URBAN COLLECTION AT PALMER VILLAGE

SITUATED IN THE NORTHEAST QUARTER OF SECTION 5, TOWNSHIP 14 SOUTH, RANGE 65 WEST OF THE SIXTH PRINCIPAL MERIDIAN, COUNTY OF EL PASO, STATE OF COLORADO.

Final Plat Drawings V1 redlines.pdf Markup Summary 1-5-2021

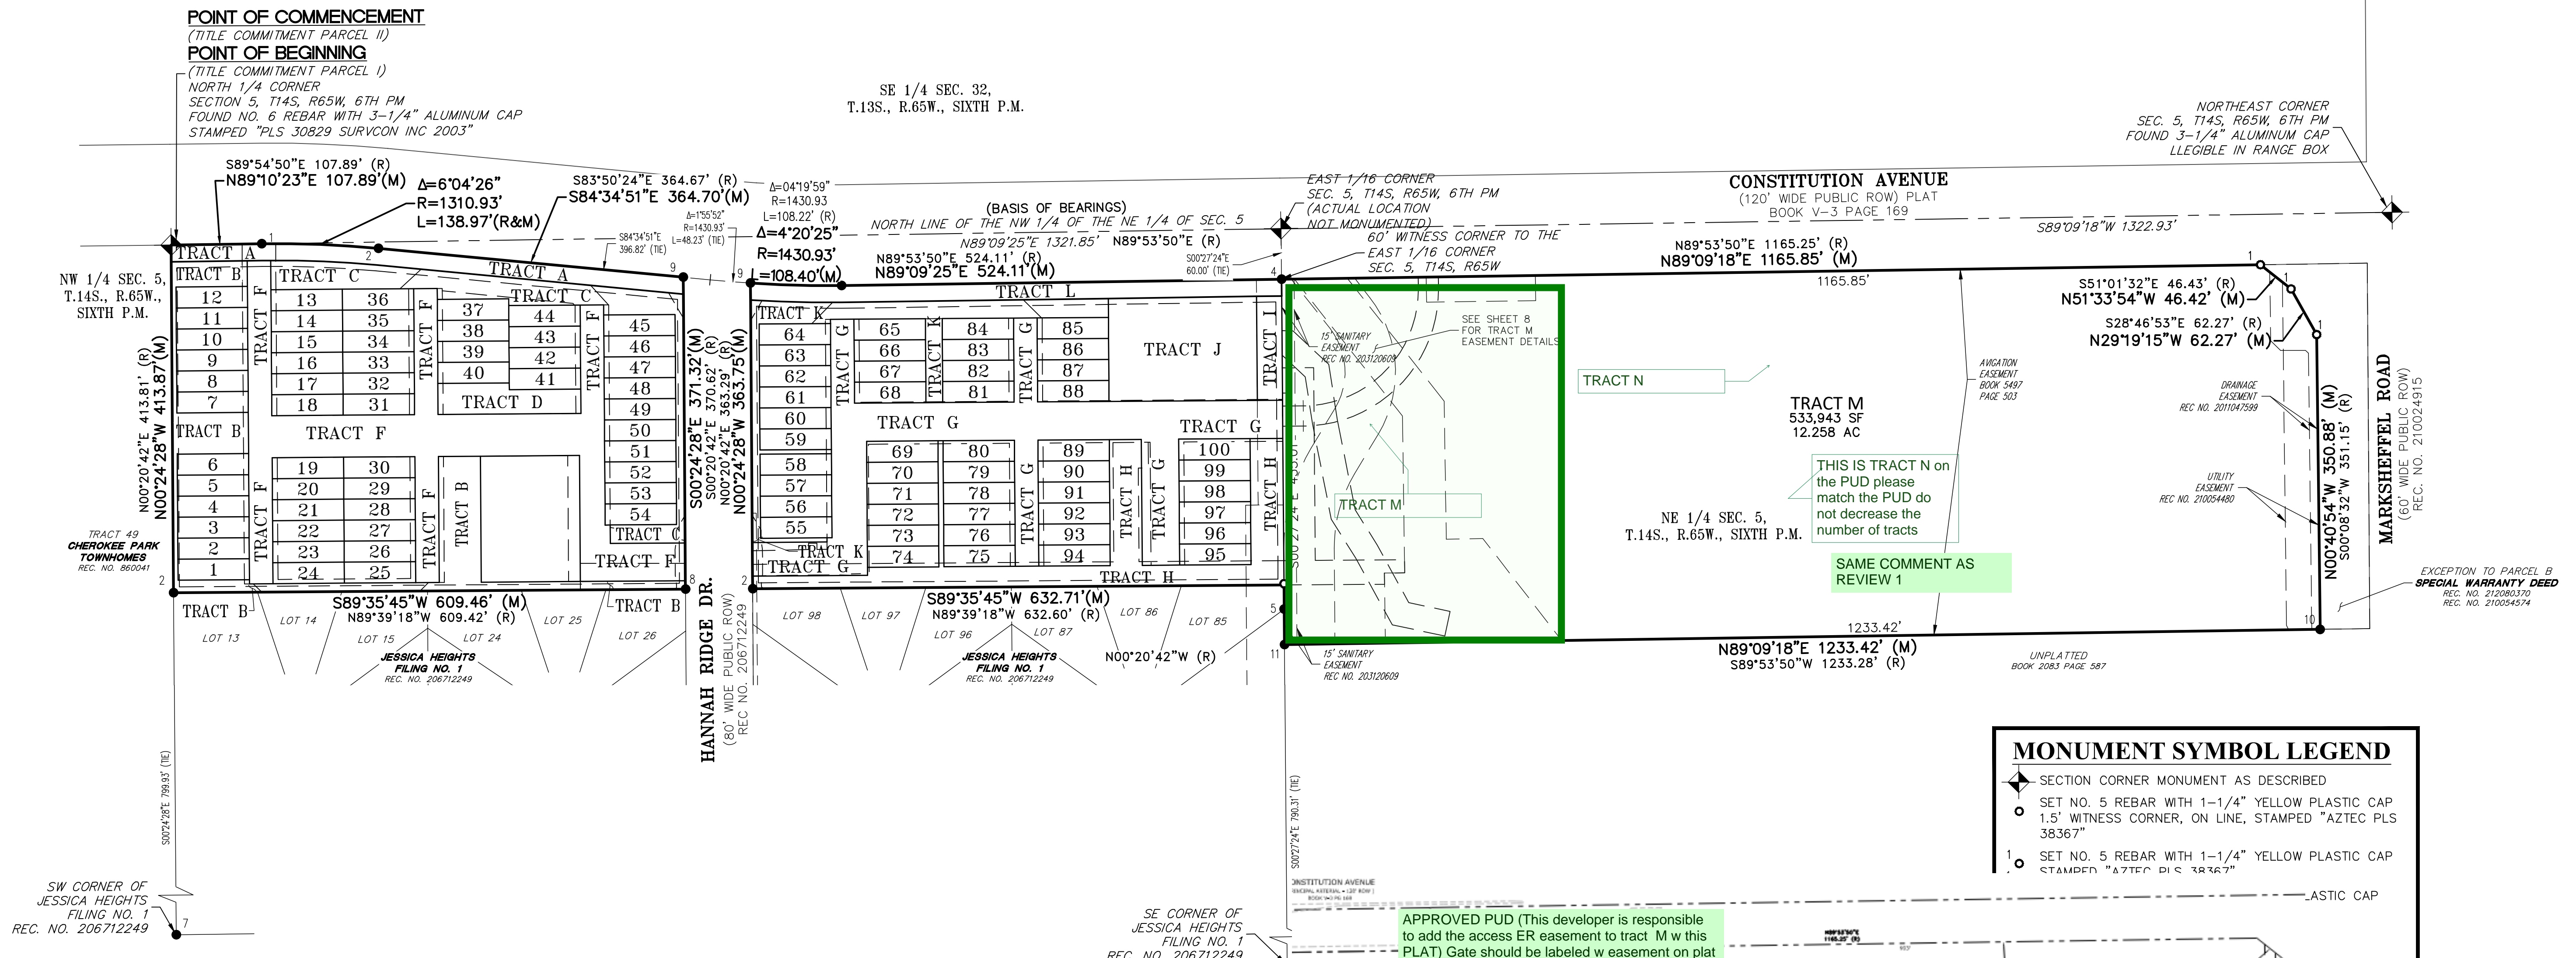
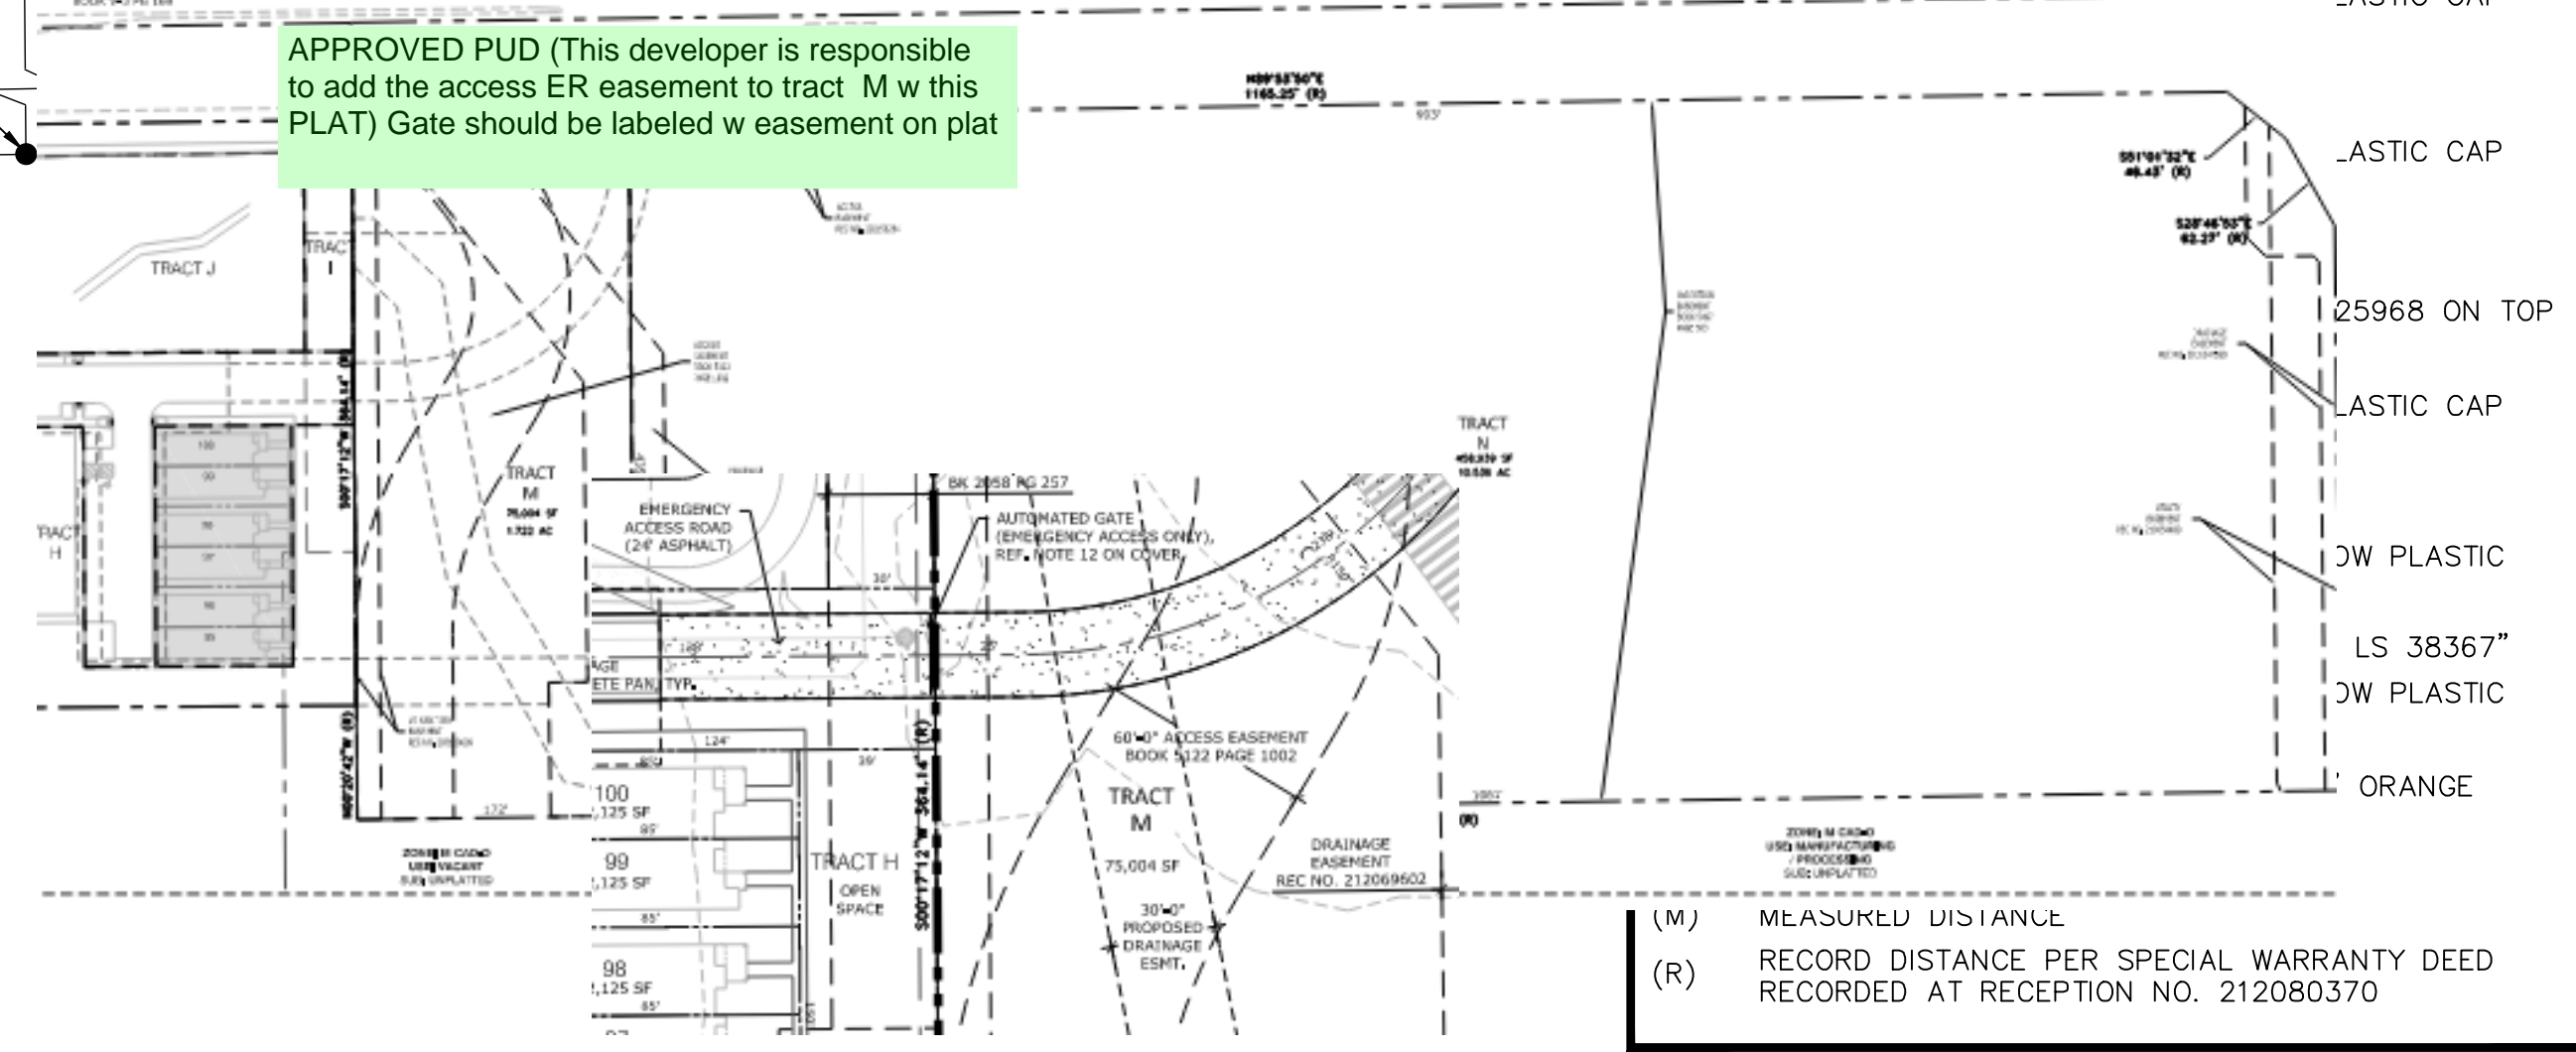
Page Label: [2] 2020-03-05 - Constitution & Hannah PLAT-S2 Tract N? Please place back on plat

Page Label: [2] 2020-03-05 - Constitution & Hannah PLAT-S2 As approved by PUD; edit plat table accordingly; changes to the number of tracts, or sizes within plat should not be made if seeking admin

Page Label: [2] 2020-03-05 - Constitution & Hannah PLAT-S2 please add tract N back

Page Label: [2] 2020-03-05 - Constitution & Hannah PLAT-S2 please provide an overall key map that is easily read when this plat printed for each sheet- it is difficult to see what sheet matches where to the

Tracts as approved; please verify plat is same as PUDSP- individual plat sheets are difficult to follow

SHEET 3 OF 8

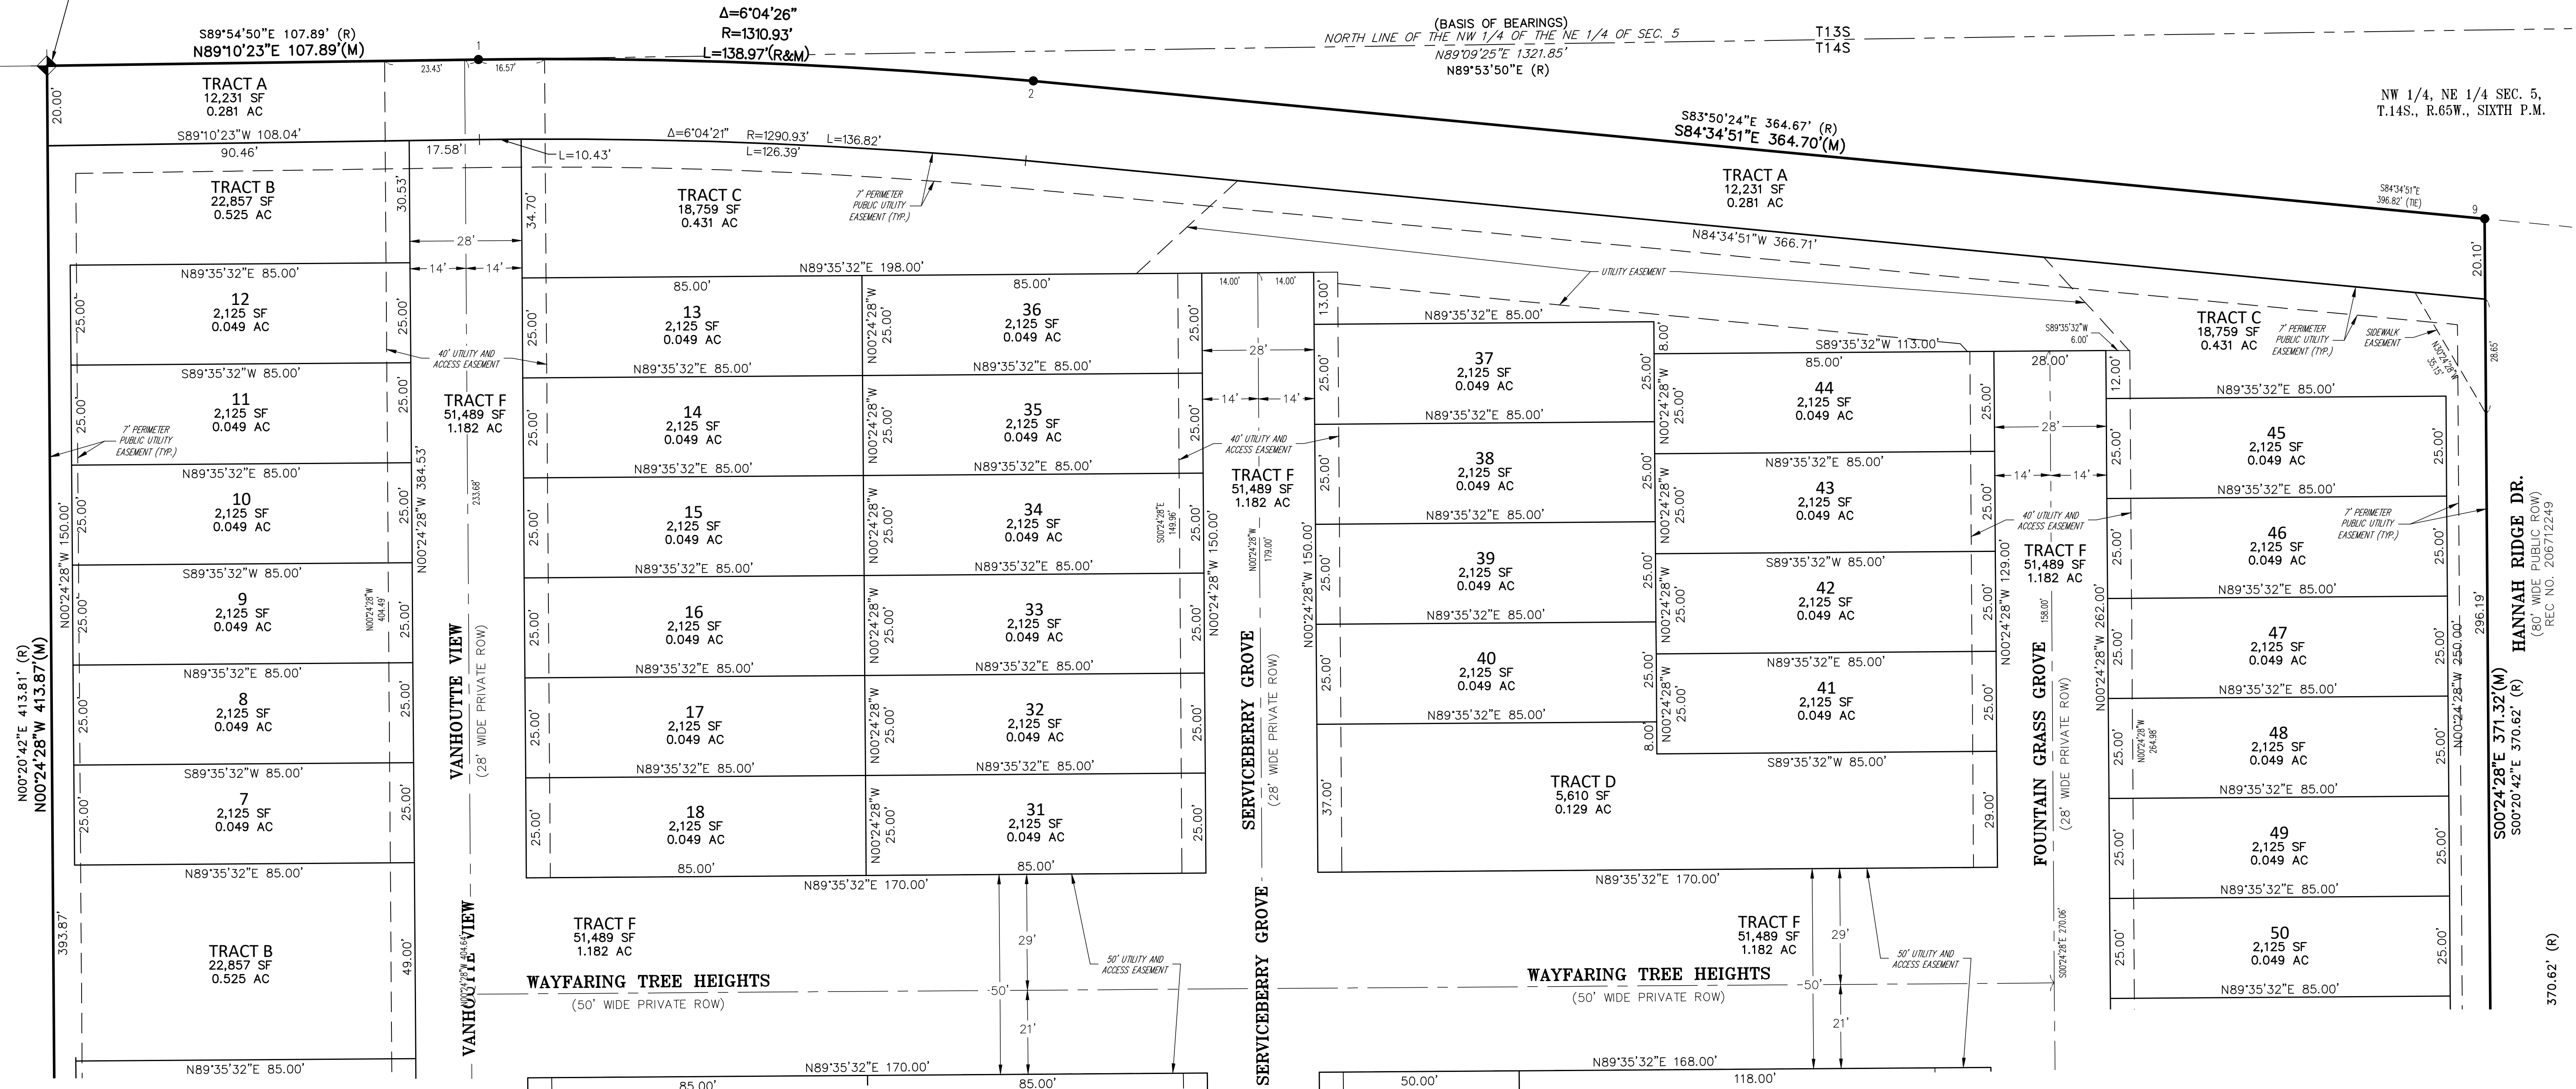
Page Label: [3] 2020-03-05 - Constitution & Hannah PLAT-S3 add detail notes
